# MEARS ASHBY PARISH COUNCIL

## Formal Written Representation and Statutory Objection to the Green Hill Solar Farm DCO Application (Ref: EN010170)

Title: Figure 12.2.4 Archaeological Assets
Green Hill C and Cable Route Corridor

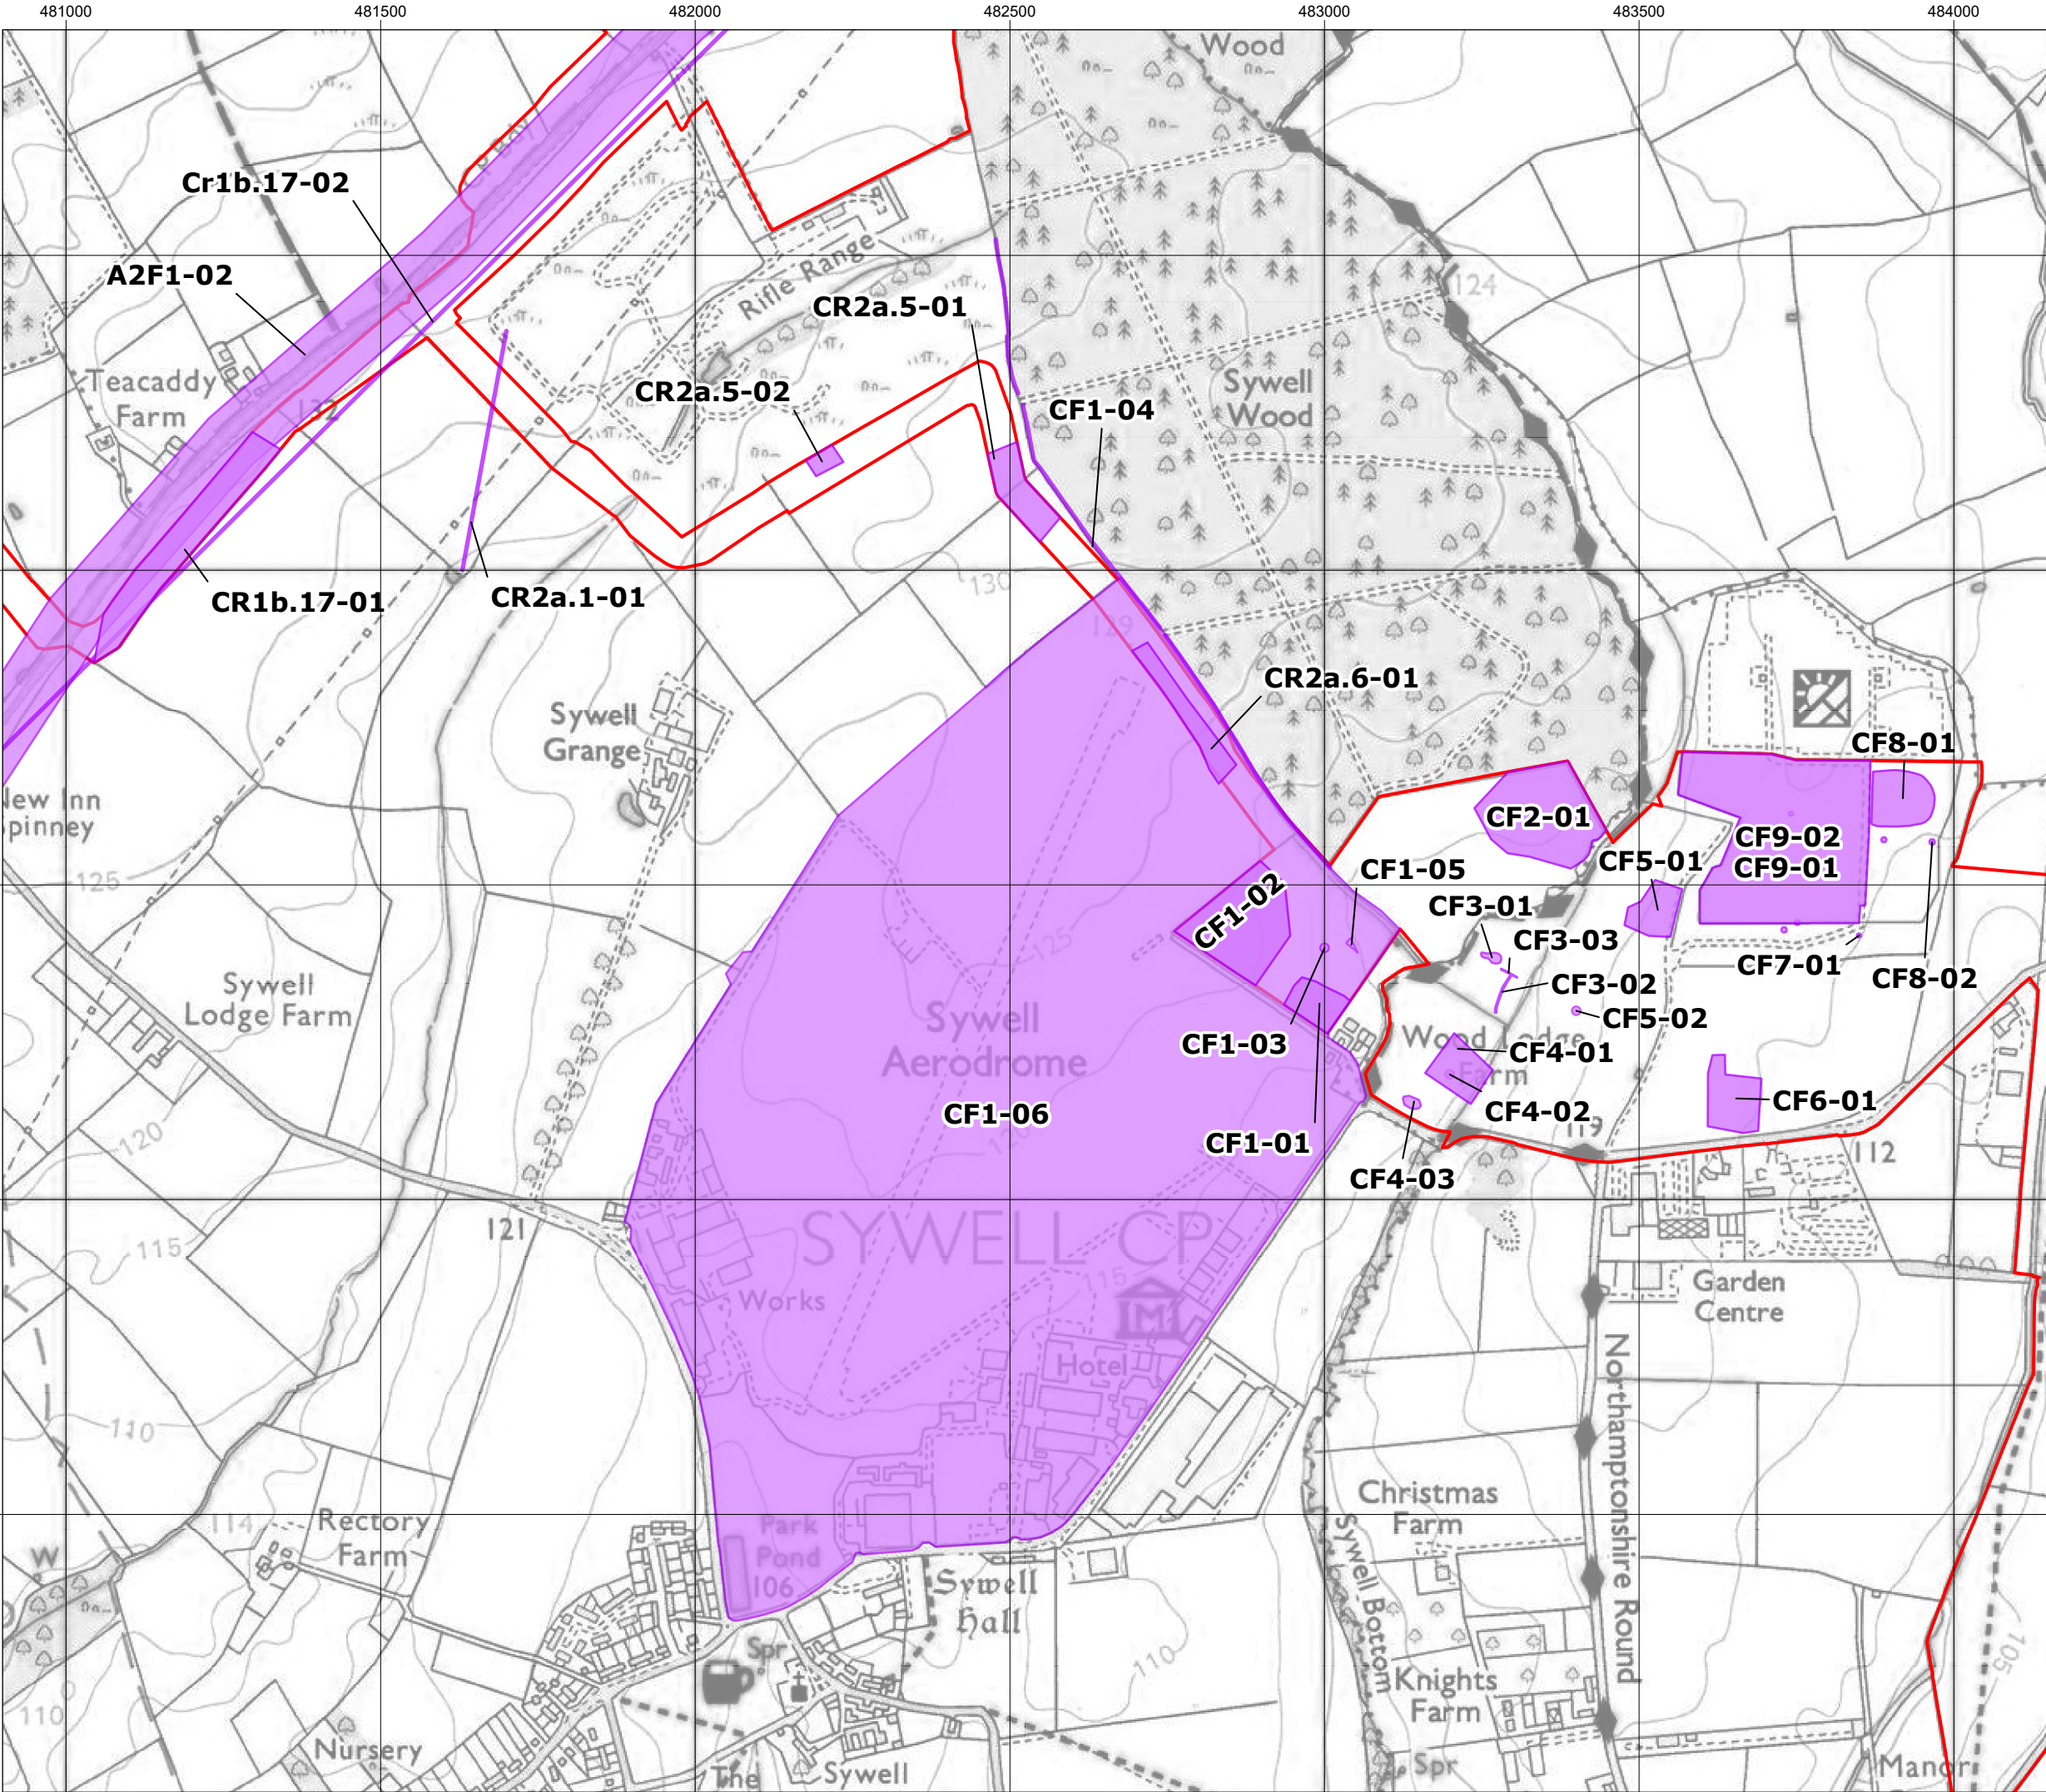
- **2.4 Conflict with Local Spatial Policy and Loss of Amenity (Areas C and D)**

The project design places intensive infrastructure across Areas C and D, explicitly enveloping Wood Lodge Farm. The proposed layout for Area D will dissect and destroy the integrity of the parish's primary and most heavily utilised public right of way (PROW). This constitutes the loss of a vital community amenity and an established wildlife corridor. This layout directly conflicts with Policy 8 of the North Northamptonshire Joint Core Strategy, which mandates the protection and enhancement of local green infrastructure and community vitality.

Title: Figure 12.2.9 Archaeological Assets
Green Hill BESS and Cable Route Corridor

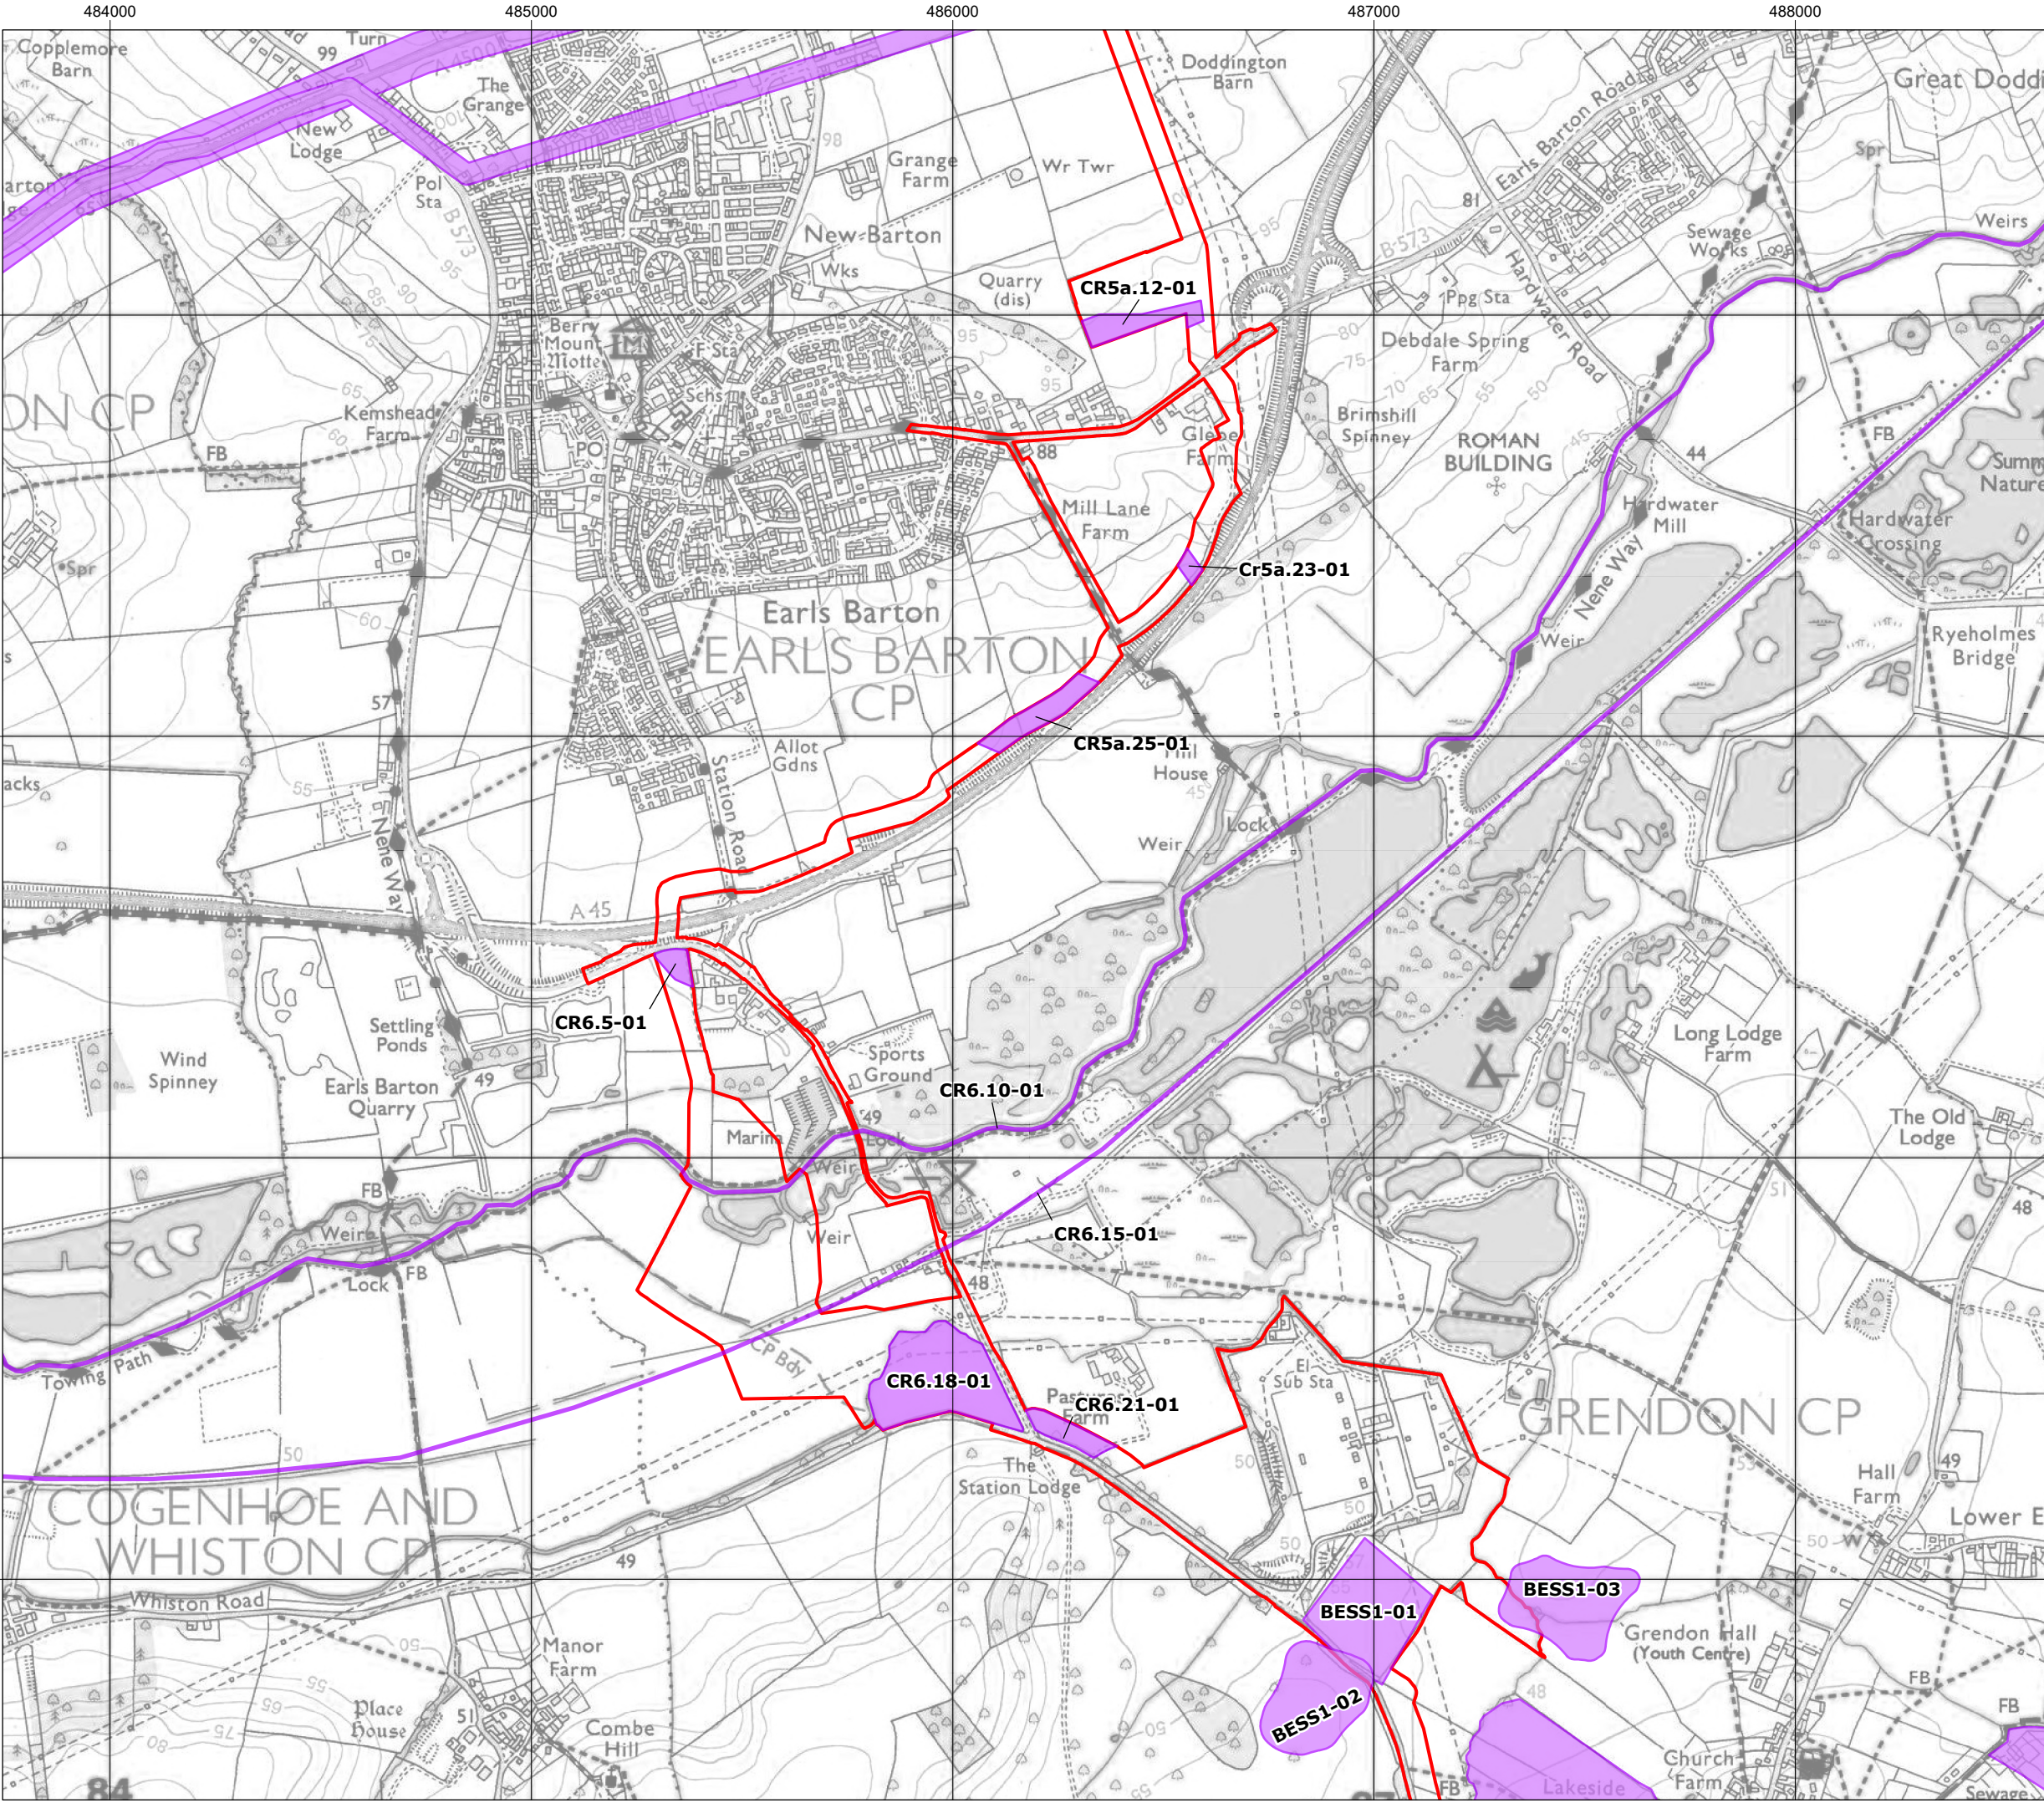
- **2.1 Unacceptable Proximity of the 9.2-Acre BESS to Sywell Ancient Woodland**  
The applicant proposes to construct a **9.2-acre industrial Battery Energy Storage System (BESS)** facility directly adjacent to **Sywell Wood**, a designated ancient, irreplaceable woodland. Under Paragraph 186 of the National Planning Policy Framework (NPPF), development resulting in the loss or deterioration of irreplaceable habitats must be refused unless there are wholly exceptional reasons. The construction and operation of a massive lithium-ion storage hub within the immediate root protection and hydrological zones of Sywell Wood will cause irreversible ecological degradation. The Parish Council strongly objects to the placement of heavy industrial chemical infrastructure against a critical, ancient ecosystem.

- **2.2 Severe Environmental Risks and Thermal Runaway Safety Hazards**  
The location of a 9.2-acre BESS facility next to ancient woodland presents a severe, unmitigable public safety and environmental hazard. Lithium-ion BESS installations carry a well-documented risk of **thermal runaway**, which causes explosive, toxic fires that emit hydrogen fluoride gas. In the event of a BESS fire, the immediate proximity to Sywell Wood risks a catastrophic forest fire that could destroy the irreplaceable ancient canopy. Furthermore, the toxic chemical runoff from firefighting efforts would inevitably poison the local water tables and the Nene Valley catchment area. The rural fire service lacks the specialized, localized infrastructure to contain a toxic event of this scale without devastating the surrounding parish.
